PLANNING AMENDMENT

Application No. H11/0083/02/H1

ELEVATION OF A PART SINGLE
STOREY, PART TWO STOREY
EXTENSION

| 01/41         | 01C              |

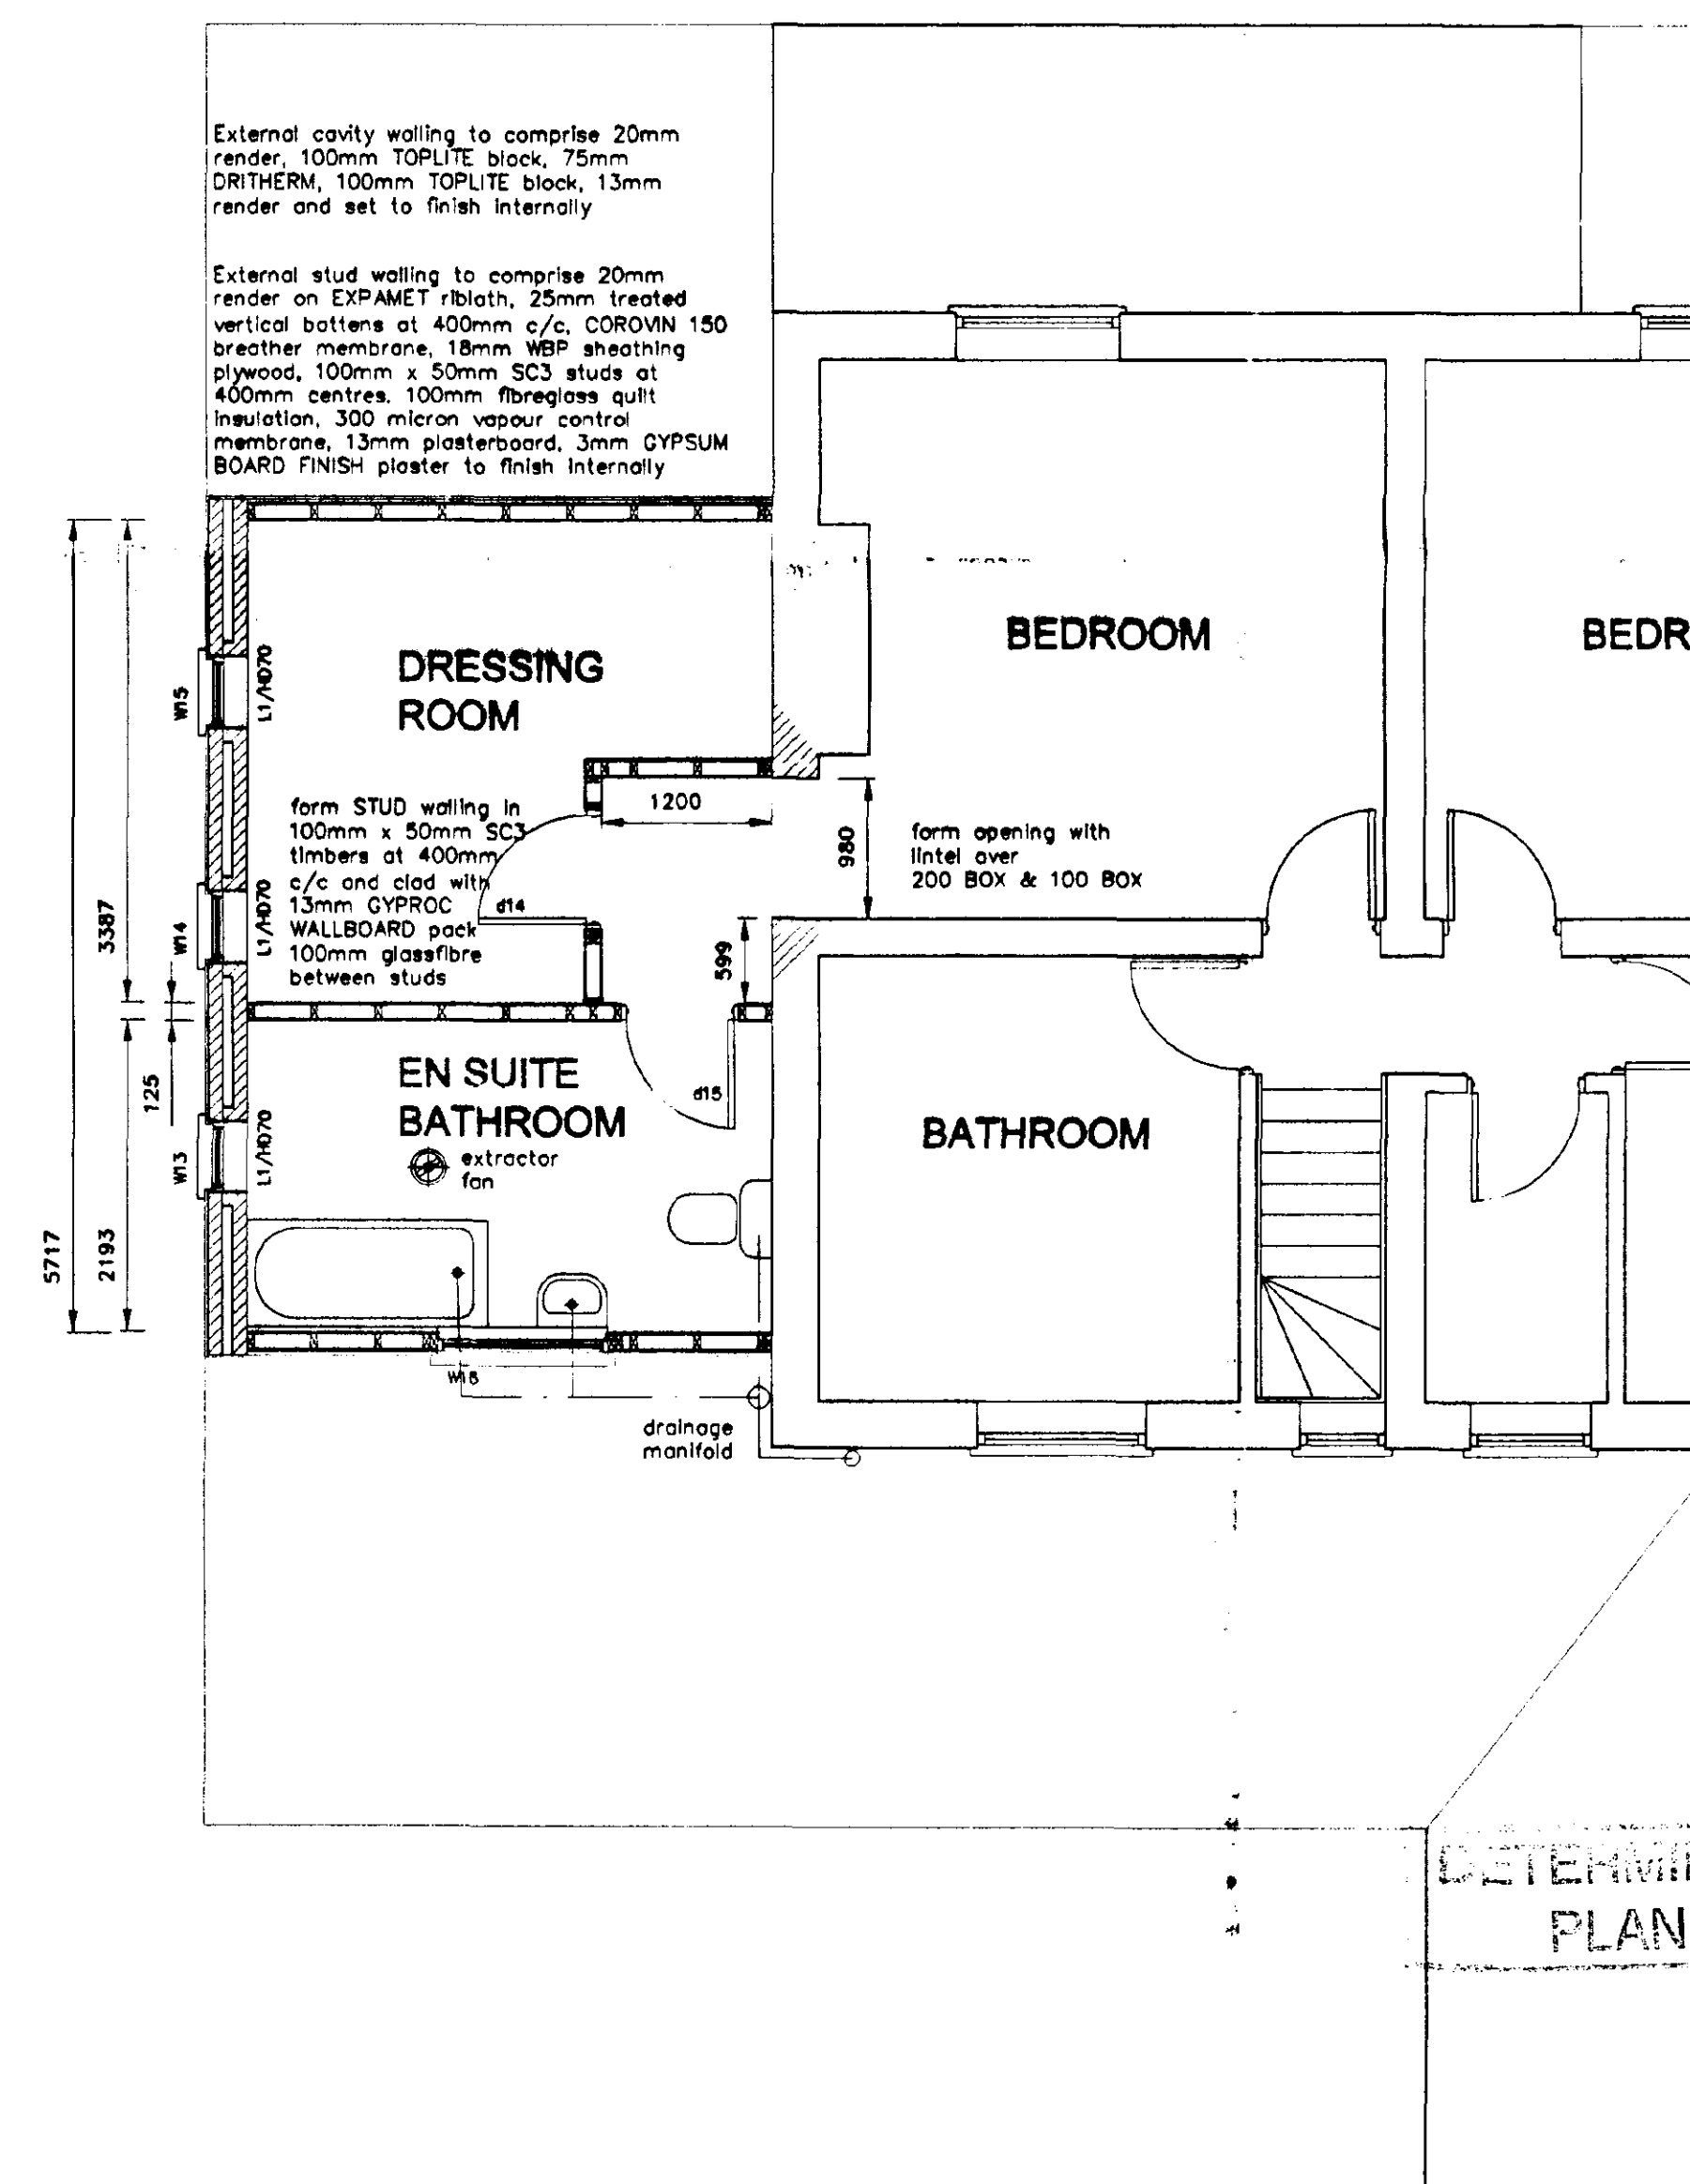
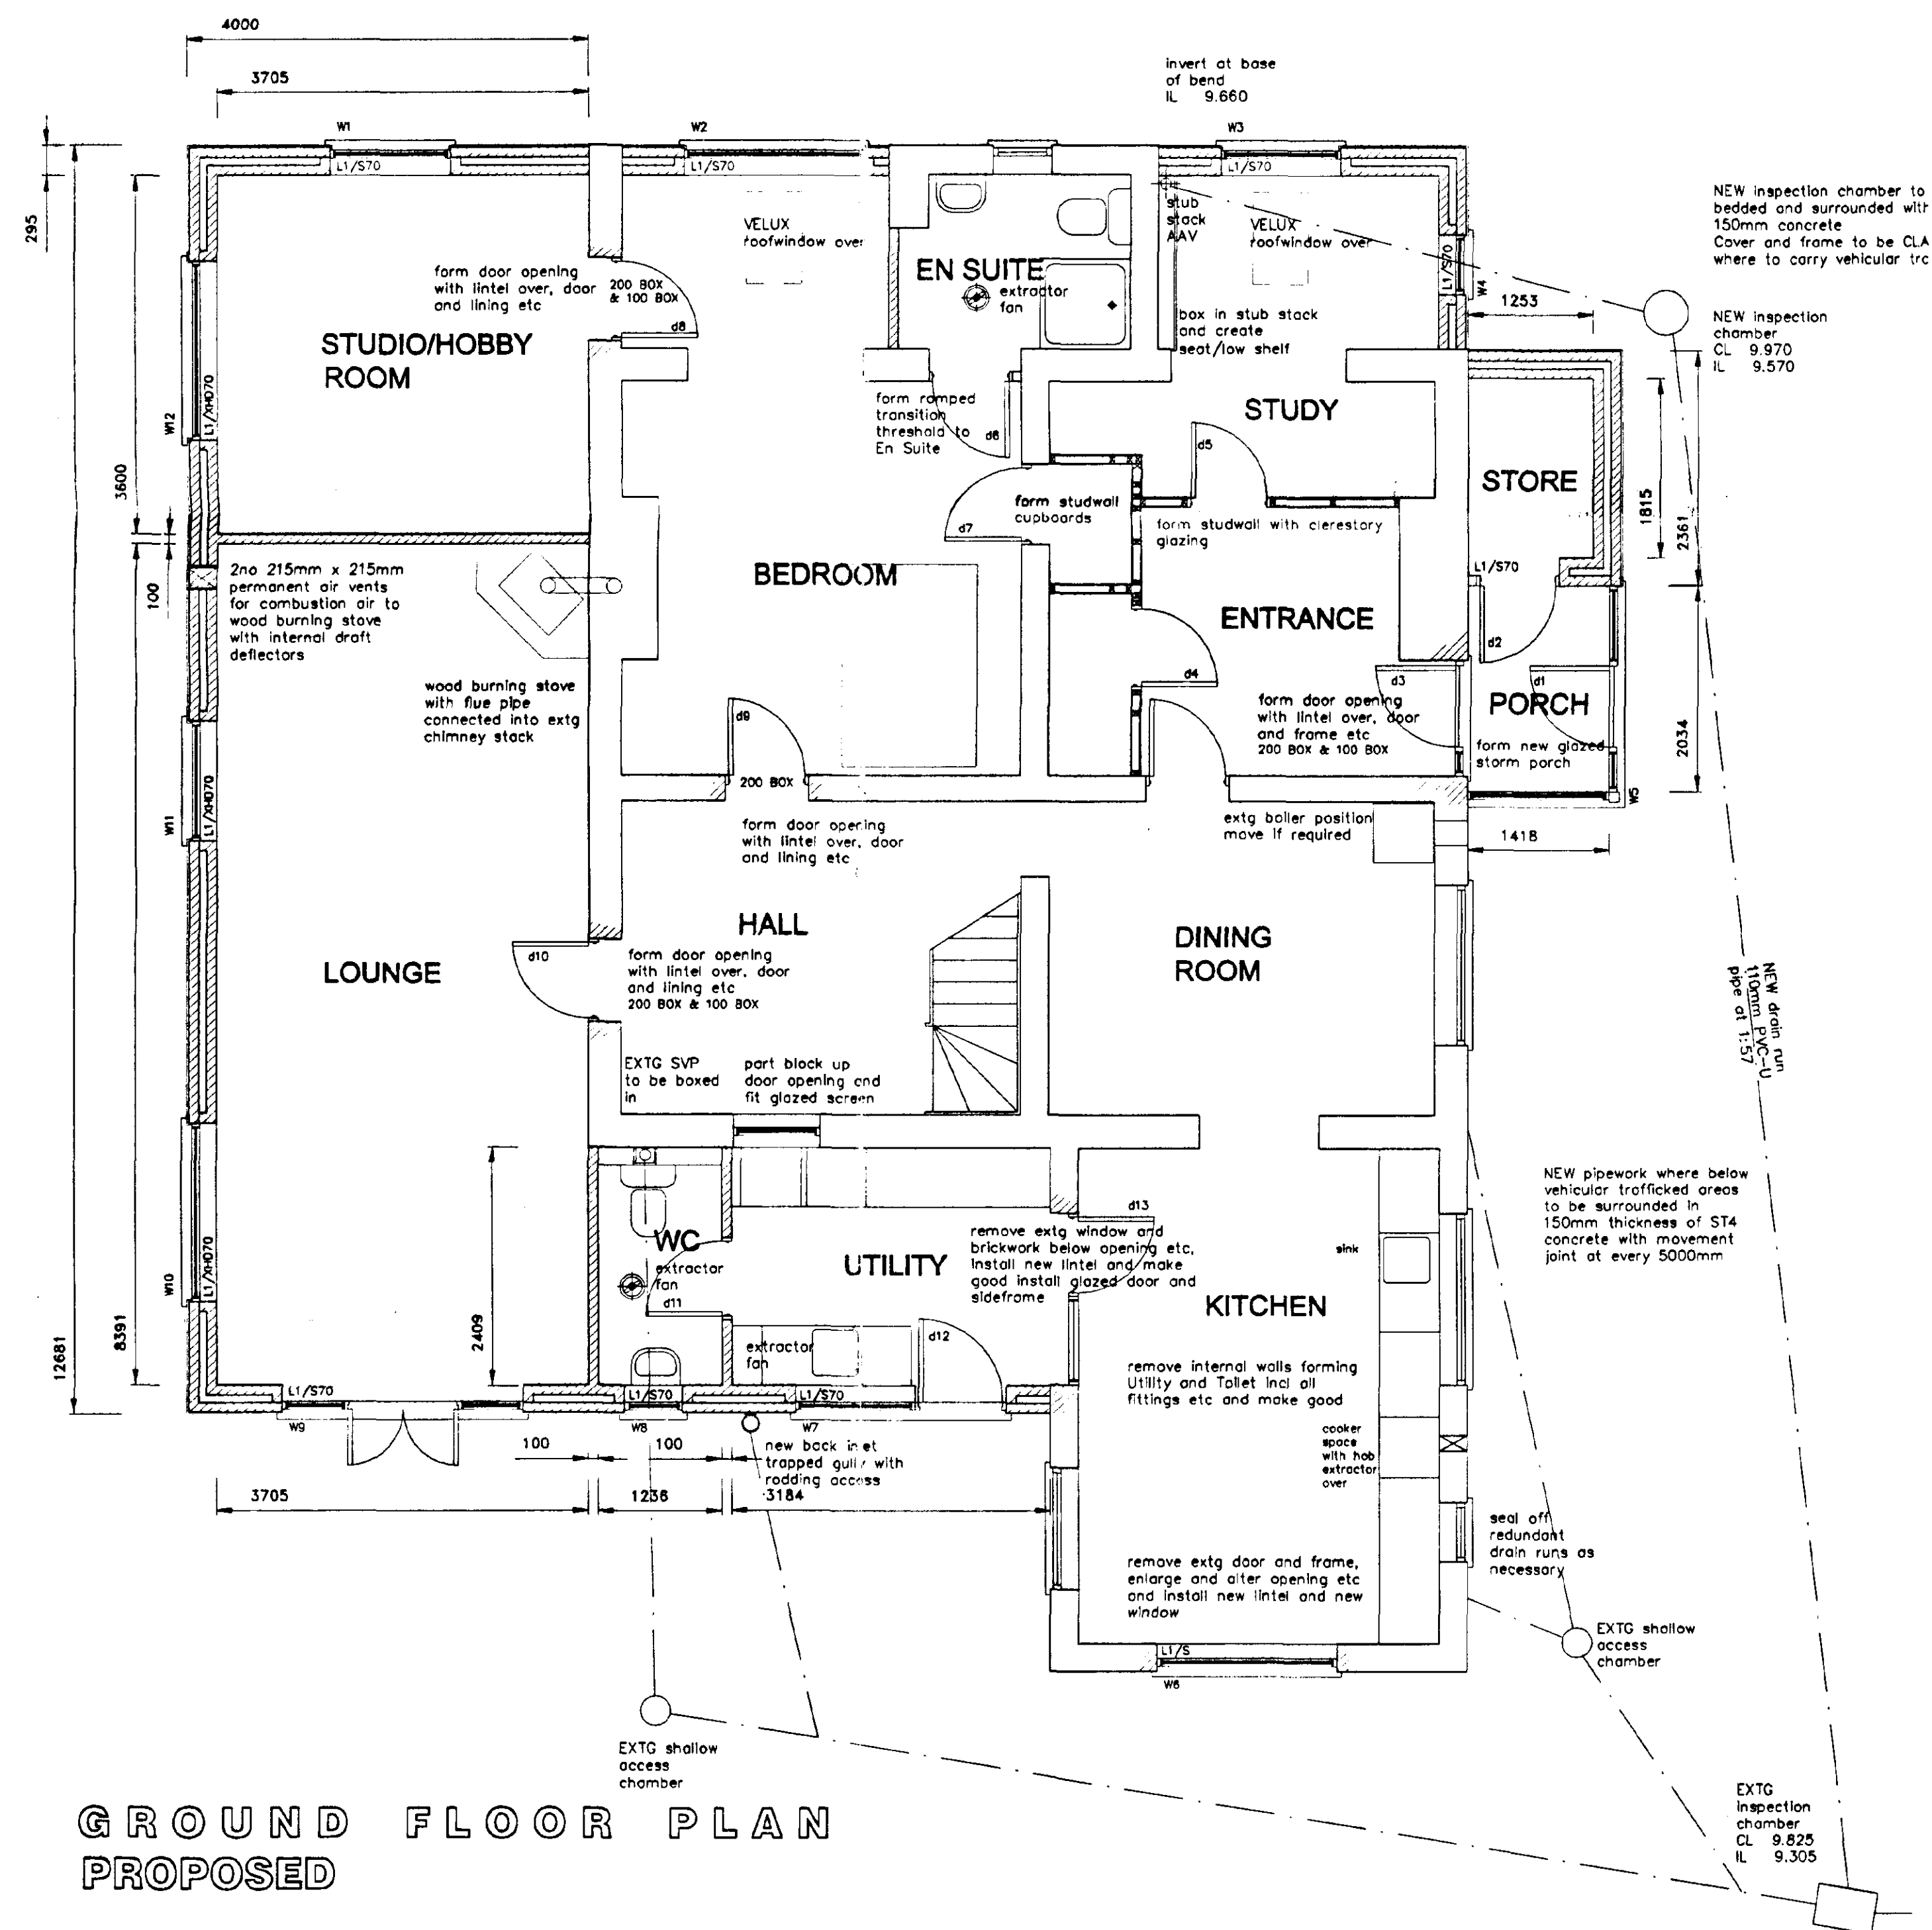
UNUSED PART OF ~~EXISTING~~ FIRST
FLOOR ROOF LEVEL AN EXTENSION
TO MATCH RICH LINE OF
MAIN ROOF

01/41/01C
